Planning Application Ref: BN/29/20/DOC

Location: Land at Angels Nursery, Yapton Road, Barnham, PO22 0AY

Description of works: Approval of details reserved by condition imposed under ref BN/93/19/PL relating to **Condition No 15 - tree protection** and 27 - Construction Management Plan

Figure 2 Default specification for protective barrier

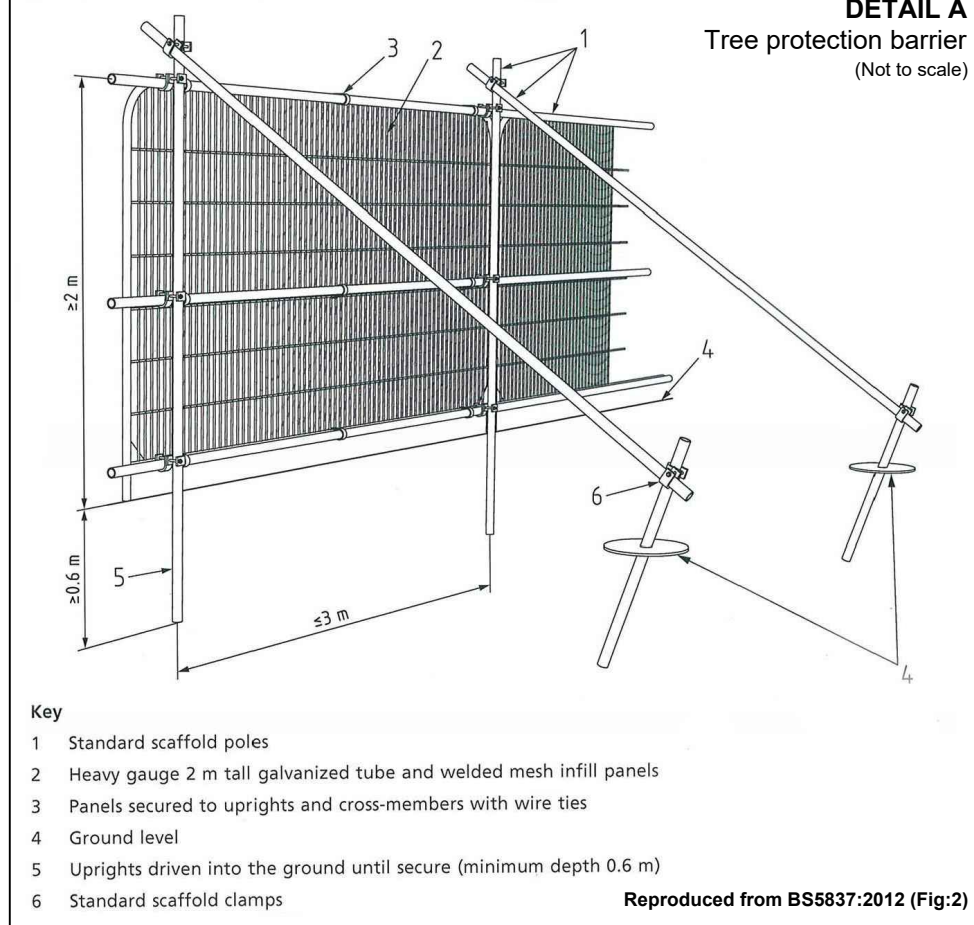
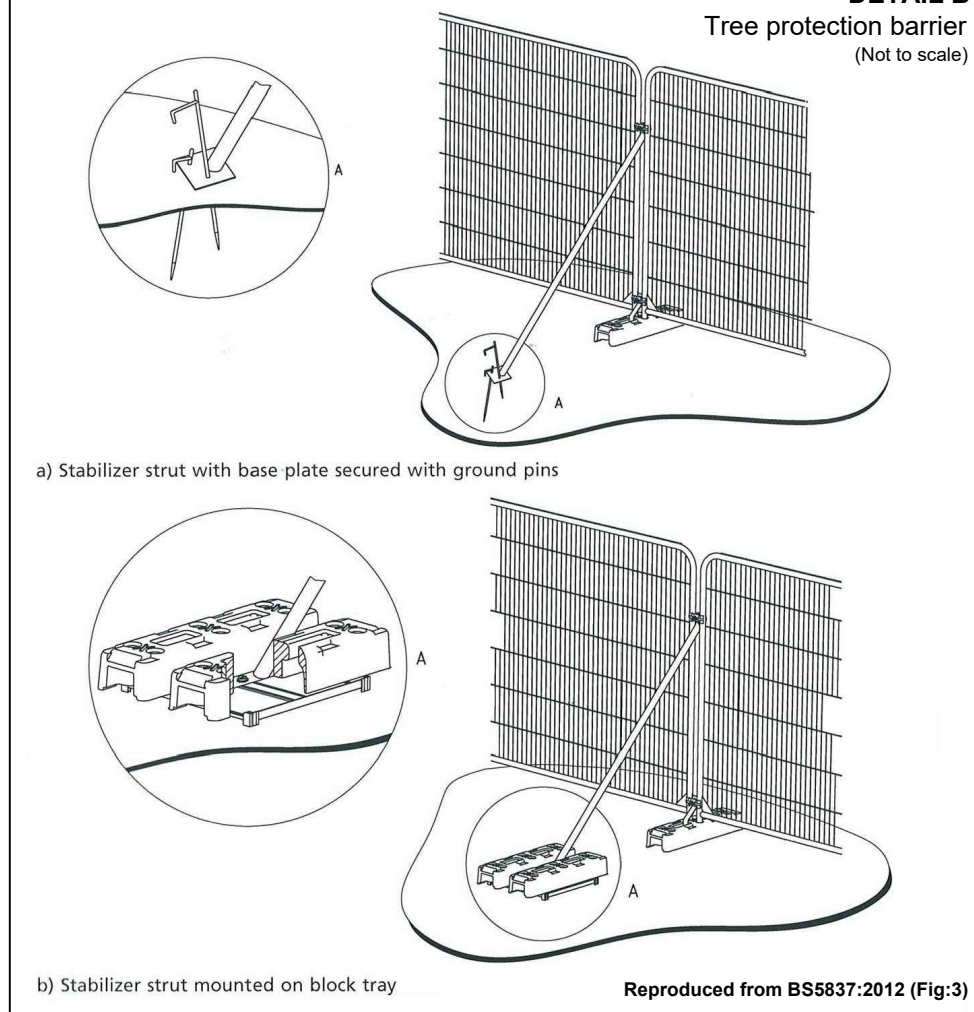
- I visited this location on 30th March 2020. It is a secure site with no permitted access. I was only able to partially view the interior from the main entrance and by heading a short distance south along the west boundary.
- West boundary perimeter fencing was available for close inspection and encouragingly of BS5837:2012 default standard. Interior fencing around significant retained trees appears to be of similar specification, although upright scaffold poles used to secure back-stays (required) have been replaced with a single stabiliser strut. I cannot be sure that all stabiliser struts are securely pegged, although some are – nonetheless, this is not of required standard.

- *'The fence will consist of "Heras" type panels or similar braced at appropriate intervals and secured to keep in place'. Those panels are to be mounted on a rigid scaffold framework supported by back-stays and vertical poles at appropriate intervals and driven a minimum 600mm into the ground – so as to be 'fit for purpose' (as per Figure 2, BS5837:2012, Default specification for protective barrier).'*
- Ad-hoc site monitoring by Planning Officers and/or Tree Officer will be undertaken soon after commencement or once the site has been opened; to ensure that the tree protection fencing meets the above specification.

Title **Tree Protection & Removal Plan**

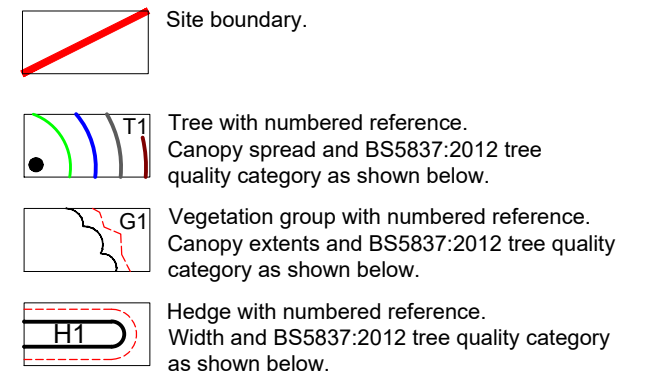
- The condition is clear in that Tree Protection Fencing (TPF) must be installed prior to commencement and importantly, in accordance with BS5837:20102. That is to say, it must be 'fit for purpose'. This development will be prolonged and involve multiple contract elements, with staged introduction of new personnel through to completion. As such, I consider it necessary and proportionate to employ the highest standard of protective fencing, which is both fixed securely and can be highly effective. This would apply to all locations where fencing is proposed, as per the Tree Protection Plan and to the specification already employed along the west boundary (<50m from B2233 Yapton Road).

- With respect to the date of this application, the exceptional circumstances nationally (Covid-19 restrictions) and in light of the majority of measures having been installed on site; it would be reasonable to discharge the condition whilst bringing to the attention of the applicant those shortcomings in TPF and our expectation that those will be resolved to our satisfaction at the earliest opportunity.
